LANDSCAPE OVERVIEW PLAN

PUD PRELIMINARY PLAN  
 GRANDVIEW RESERVE FILING 1

EASTONVILLE RD  
 EL PASO COUNTY, PEYTON, CO 80831

L1.20

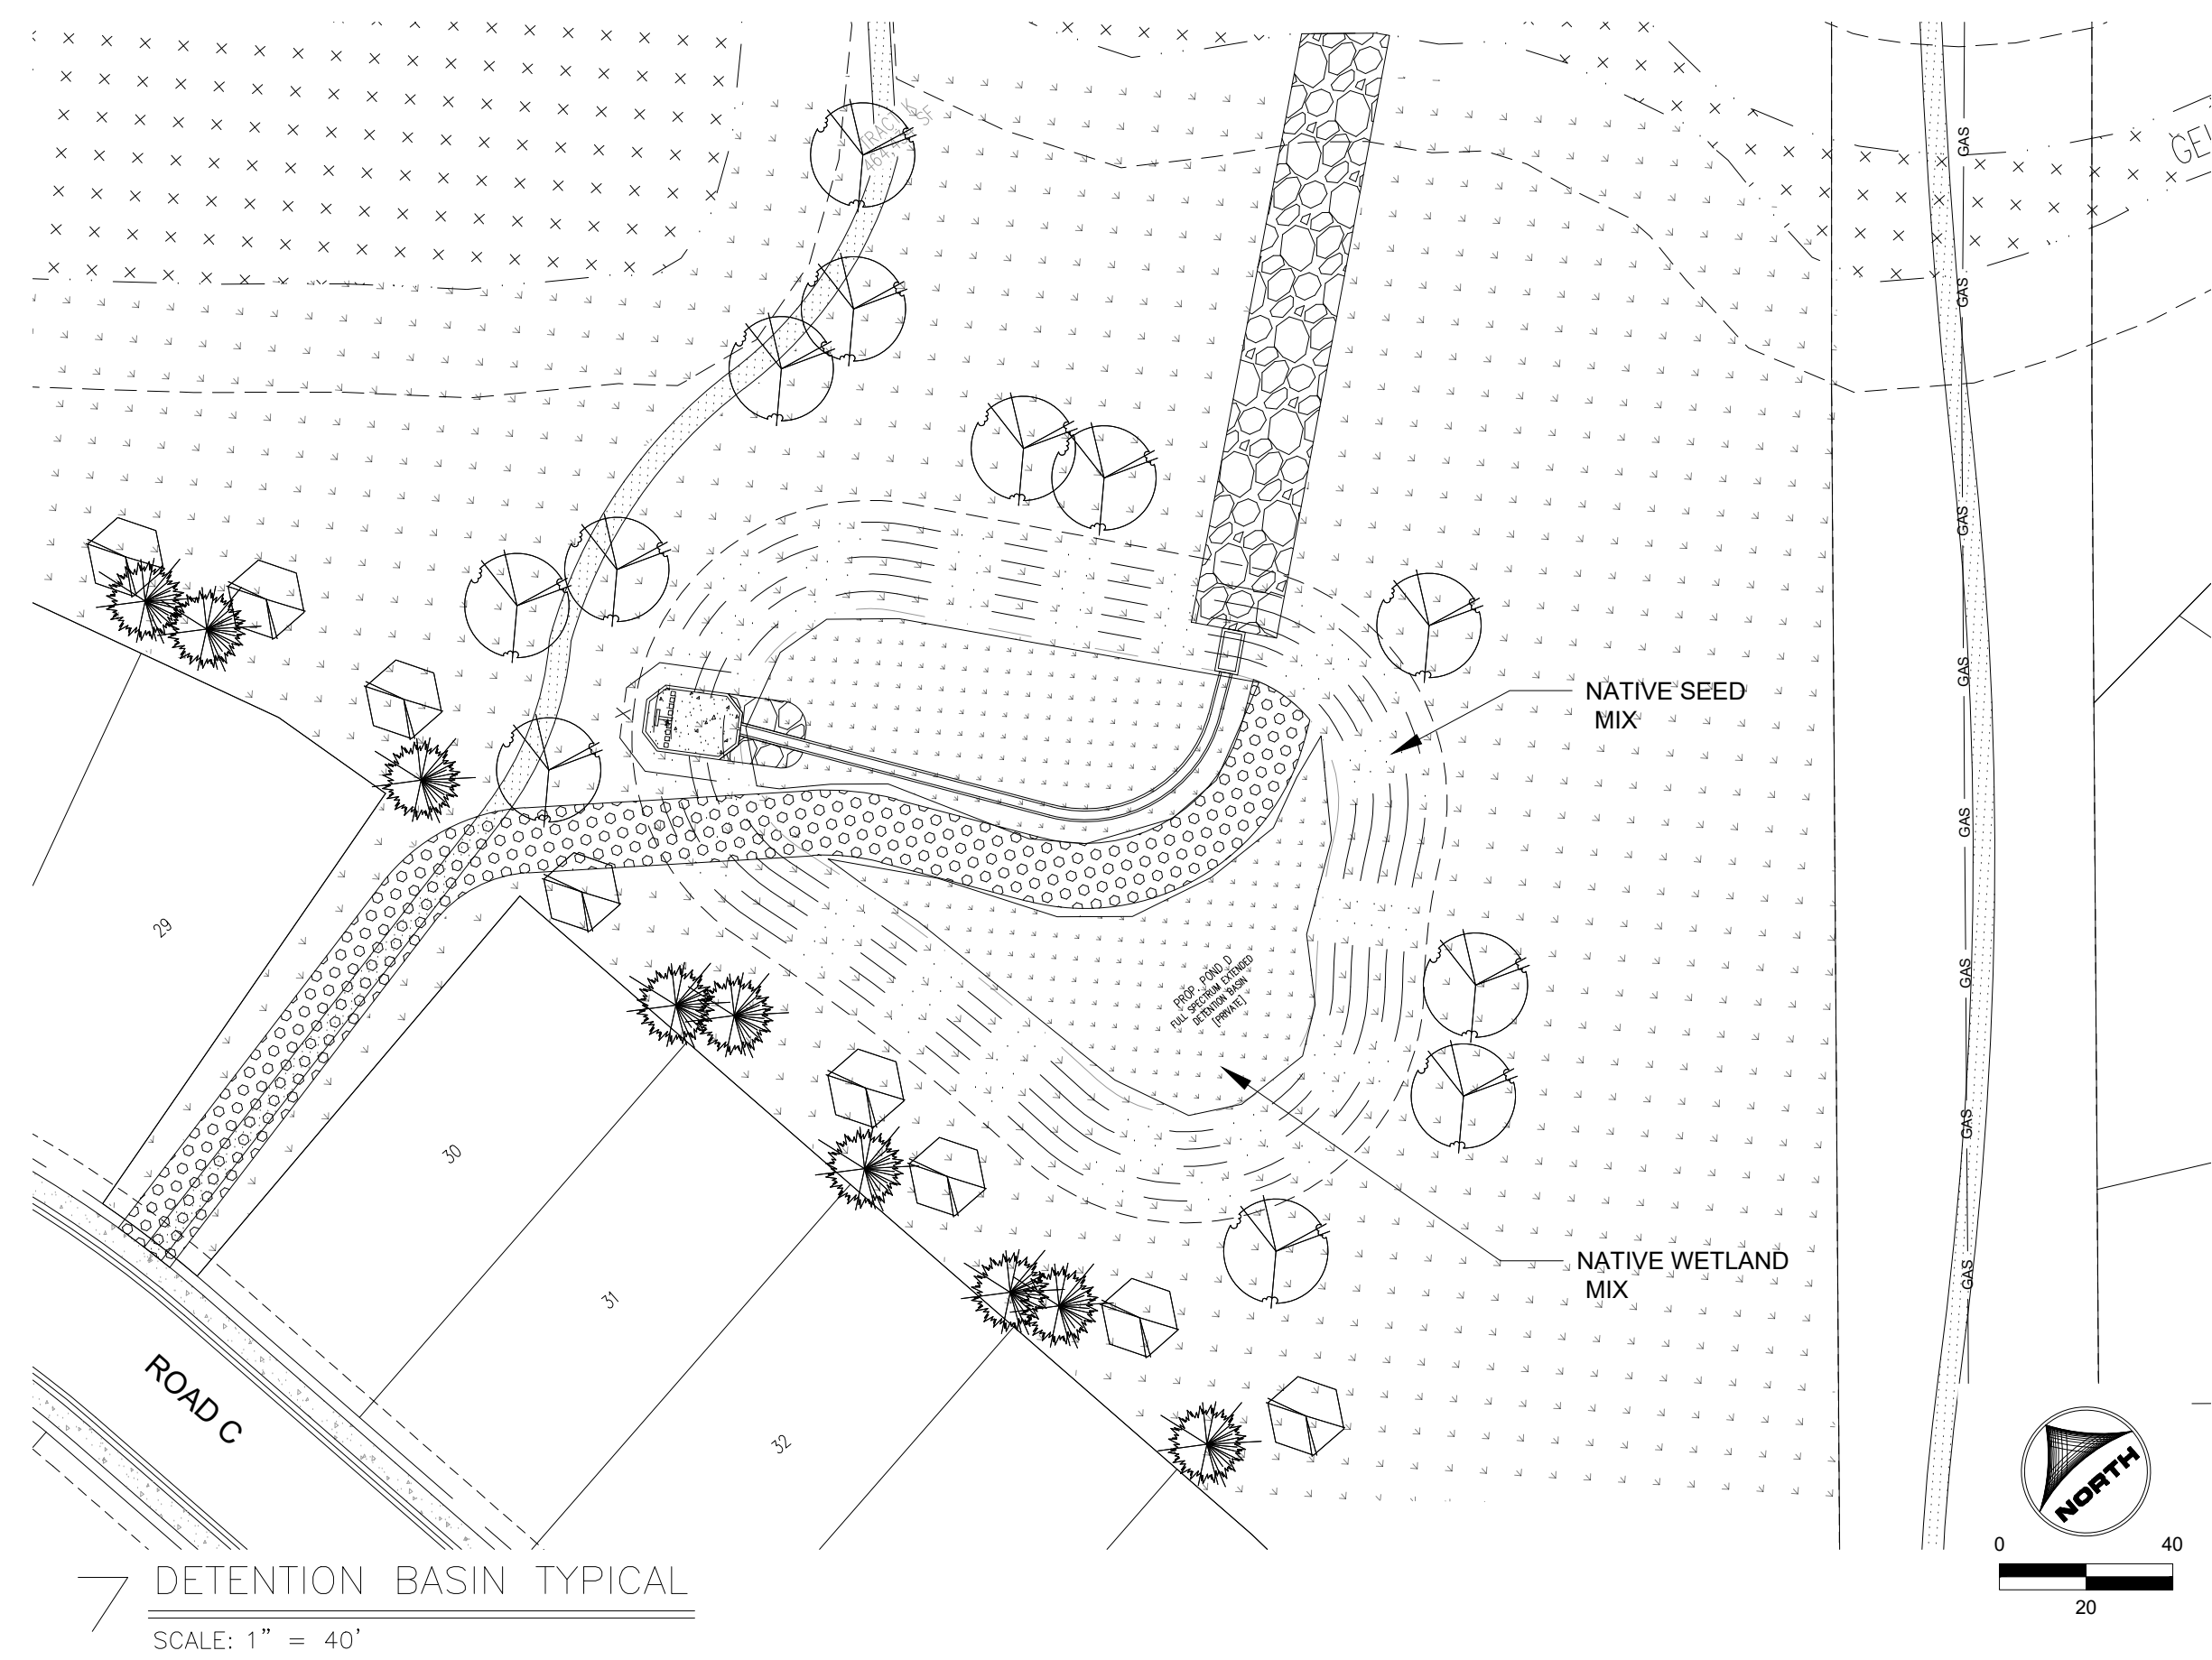
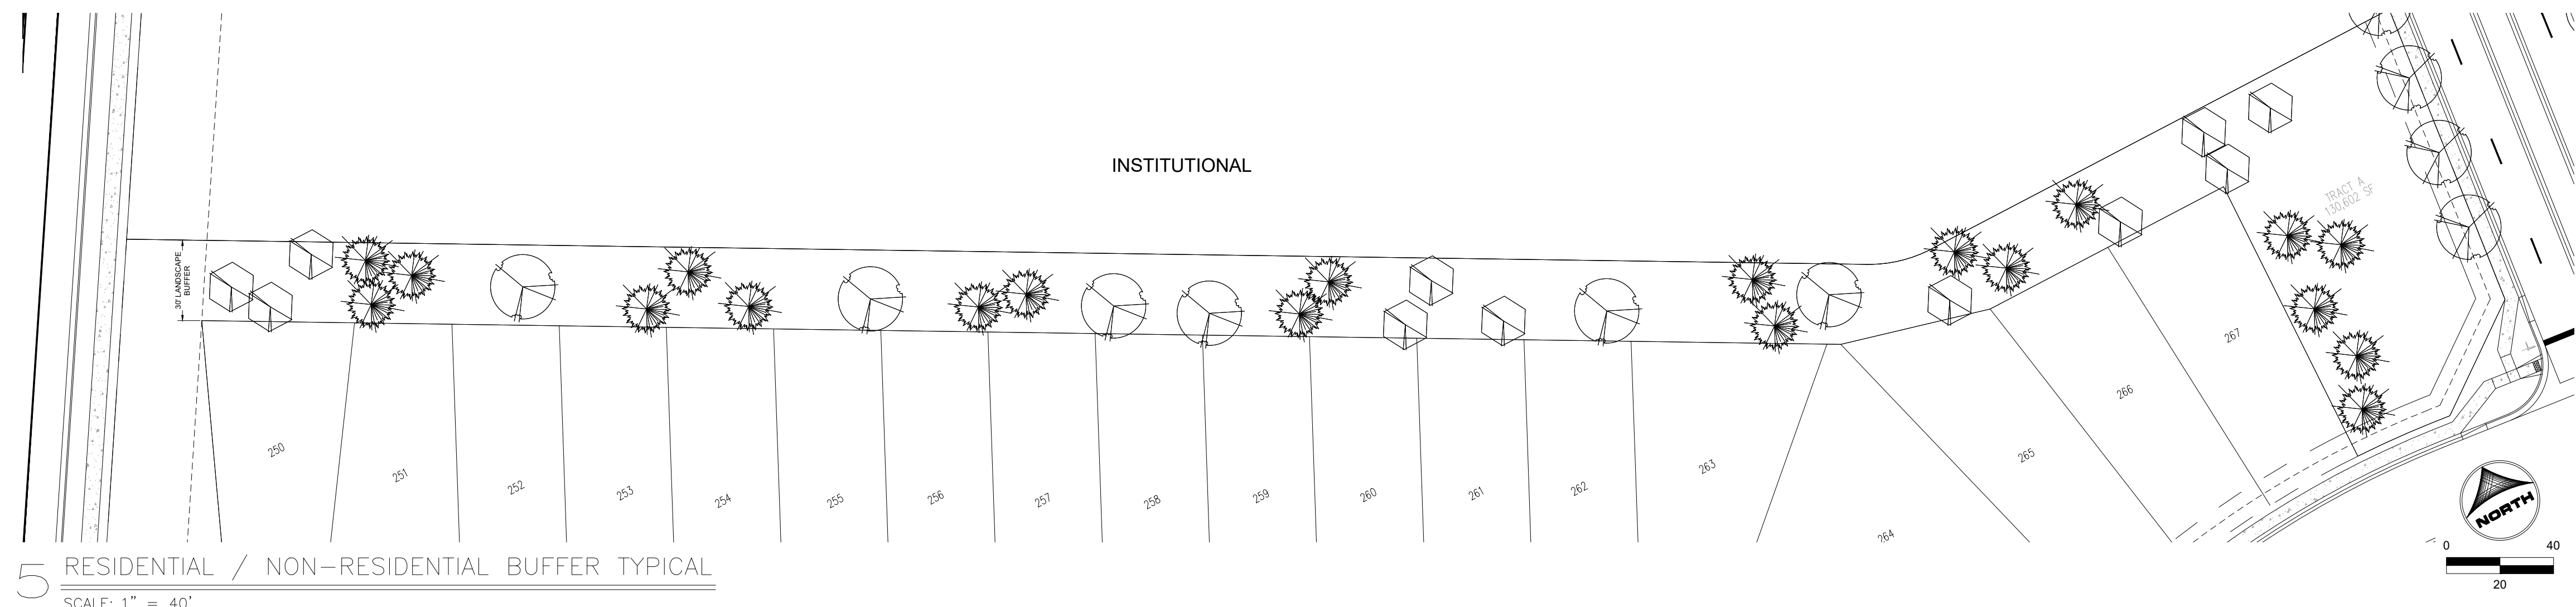
if there is an entry sign or subdivision sign provide the dimensions and detail so its a part of the specific PUD zoning or the structure will have to meet setbacks /height/ and sign code; add sight distance triangles - verify sight distance is not obstructed..Jeff Rice can help you calculate if you need clarification of the ECM.

see lanscape plan checklist - Look at PUDSP212 Skyline at Lorson Ranch or PUDSP216 Ridge at Lorson Ranch as a good example

label the setback, row lines, sidewalks trails, ; easements etc

remove all the draft or conceptual notes throughout submittal package- this is PUD zoning this will be the minimum requirement

ROW needs to be behind curb and gutter and trees behind the ROW.
